Department of Fish and Wildlife

December 16, 2010

Subject: Request for Parcel Segregation, Gene Brain Family, N1/2, Section 1, T18N, R16E –
Proposed Bridge over Taneum Creek to serve lots 1-6 of 8 lots.

RECORD OF SURVEY
 PREPARED FOR
GENE BRAIN
 A PORTION OF THE NORTH HALF OF SECTION 1
 TOWNSHIP 18 NORTH, RANGE 16 EAST, W.M.
 KITITAS COUNTY

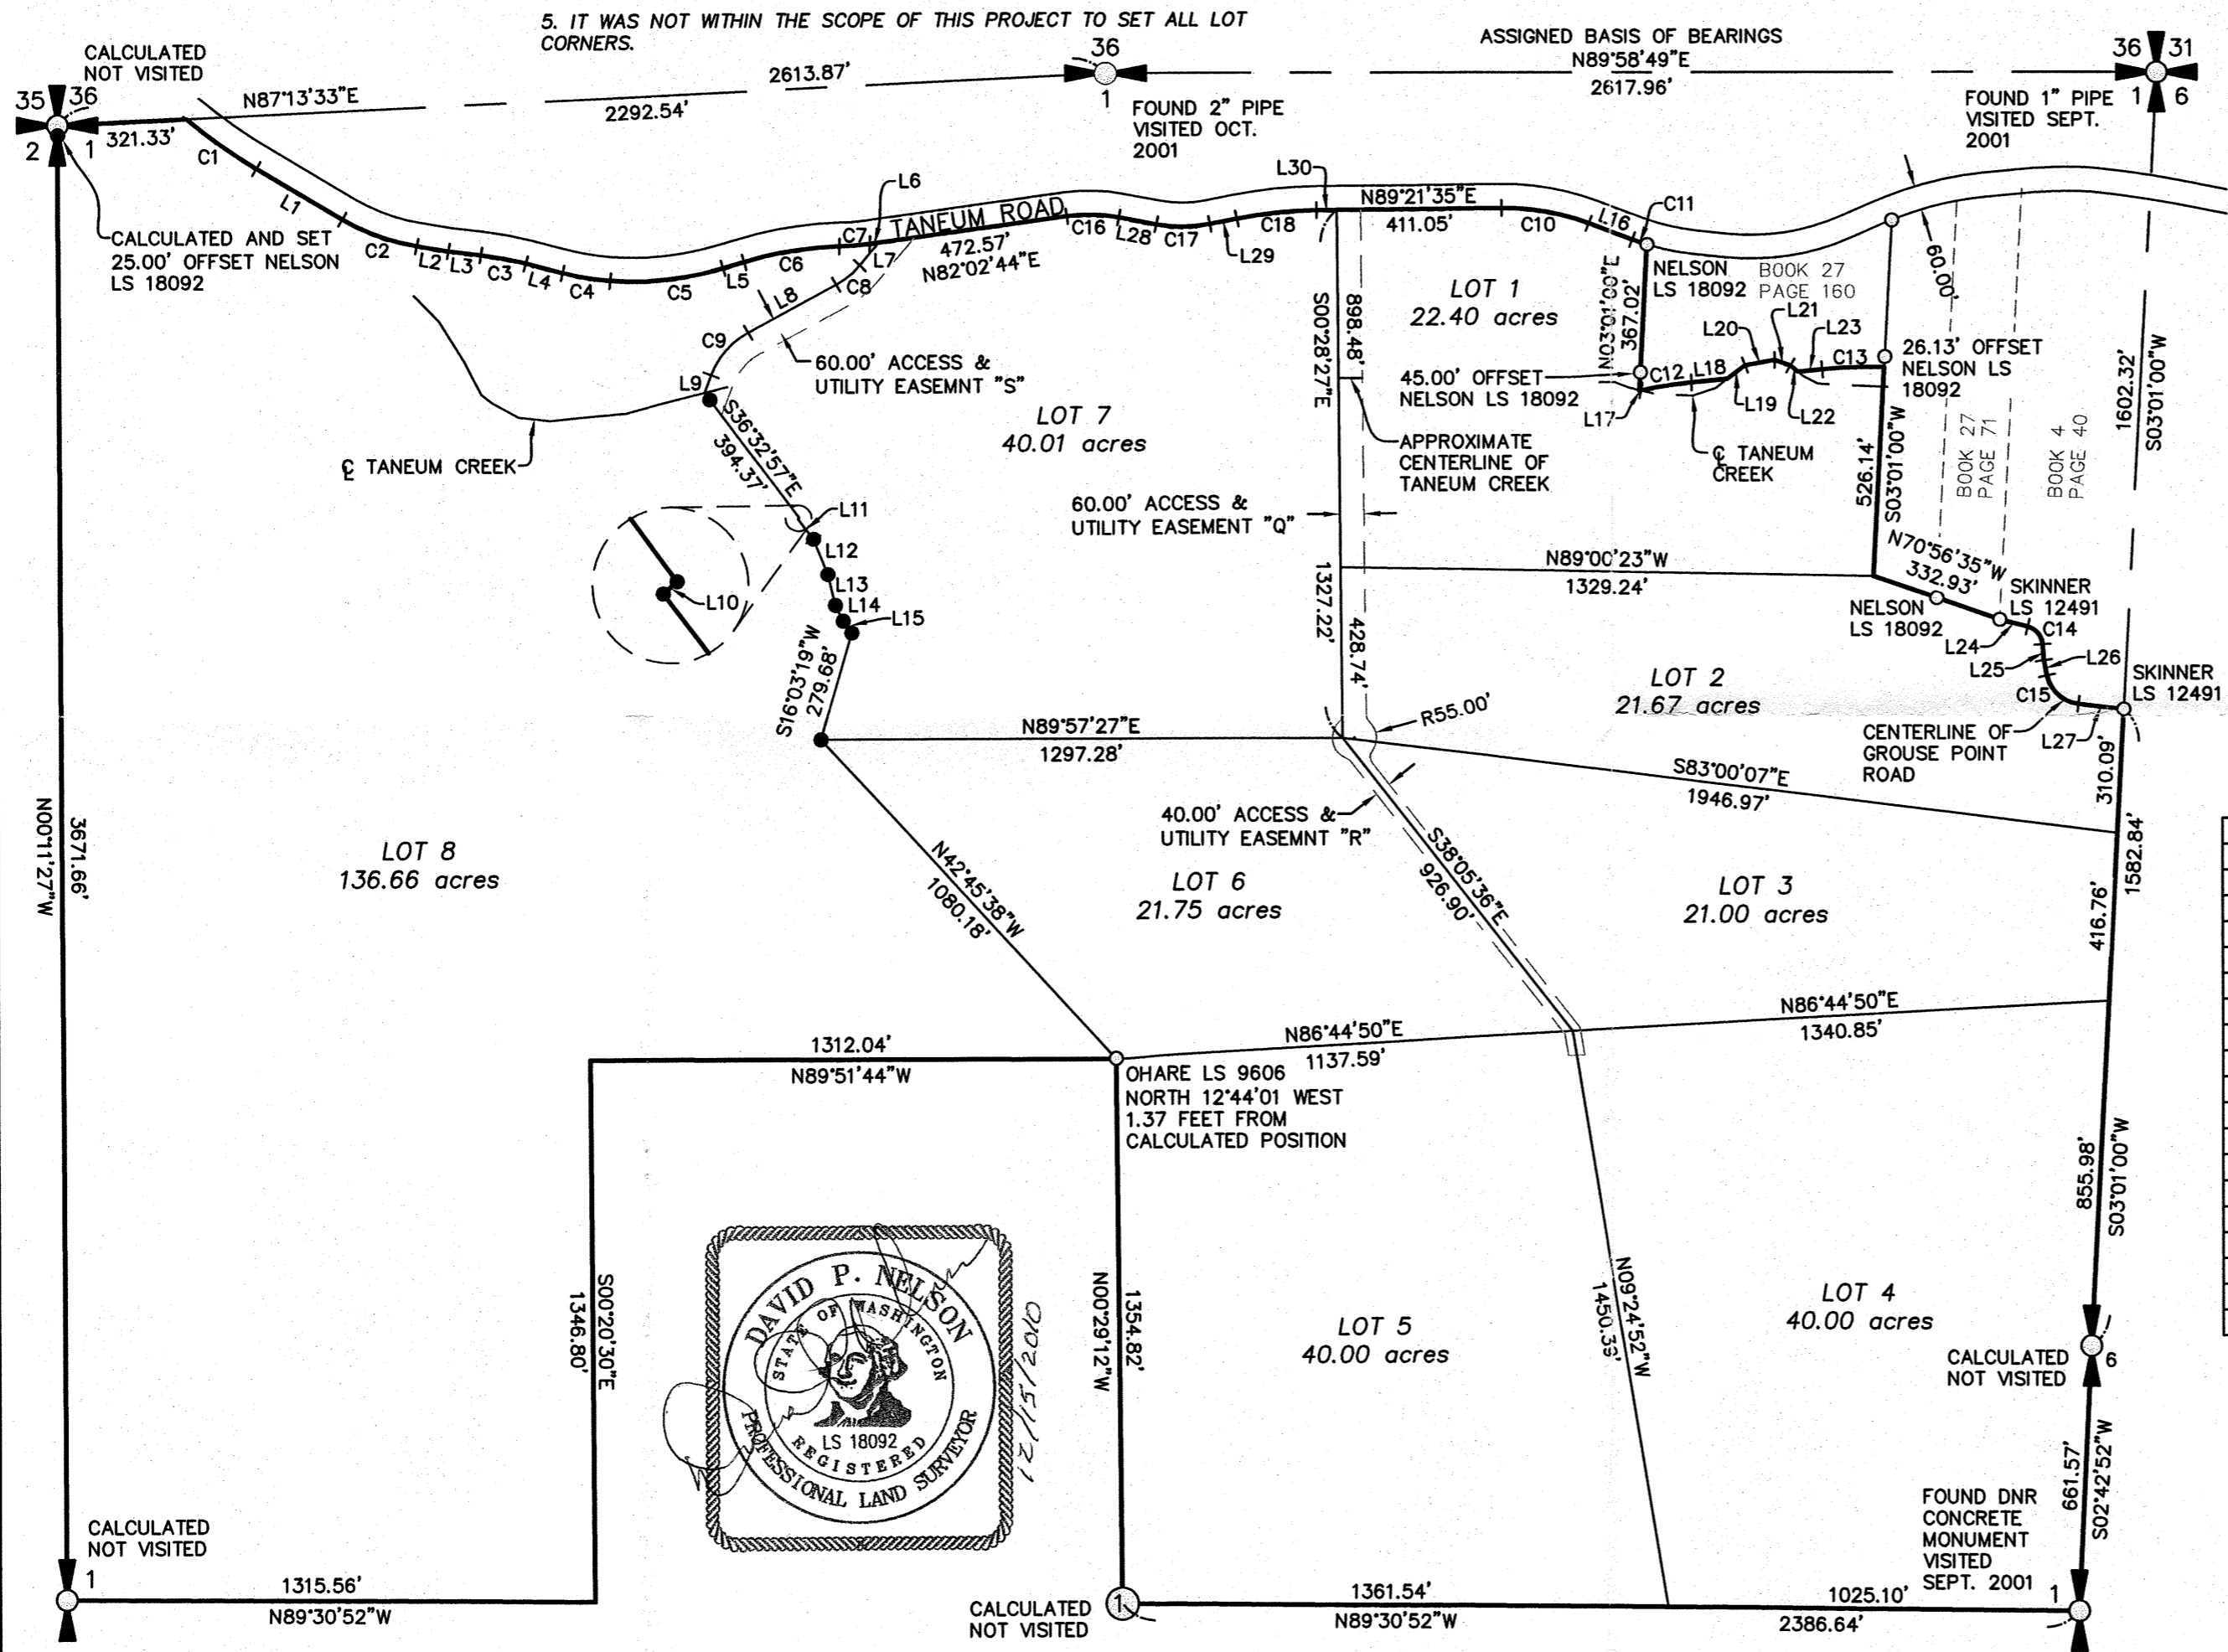
The best location on this parcel for a bridge is the site of the existing bridge. Shoreline, riparian and floodplain conditions at the proposed new bridge site are such that constructing a new road and bridge at this proposed new site would have more adverse impact on the shoreline and habitat for fish than upgrading the bridge crossing at the existing bridge site. Based upon our field visit, review of aerial photographs, floodplain maps, and our knowledge of the watershed, WDFW requests that the existing bridge location be used (upgraded if necessary) to serve the proposed lot segregation.

A new bridge in addition to the existing bridge would have significant adverse impacts on the shoreline and fish and wildlife habitat. We request that only one bridge crossing be approved for the parcel, regardless of the number of lots segregated.

The best bridge location in the parent parcel is the site of the existing bridge where the channel is most confined and has minimal functional floodplain. A bridge located at this location has the least adverse affect on the character of stream, shoreline and habitat for fish. It would be better to apply the investment needed to create a new long-span bridge at a new crossing location to the existing crossing site to bring it up to county road standards. We request that the existing bridge location be used to serve the proposed lot segregation.

We request that the road layout shown in the survey be modified to show access to the parcels via the existing bridge site. We also request that notes be added to the survey clarifying that there will only be one bridge crossing of Taneum Creek.
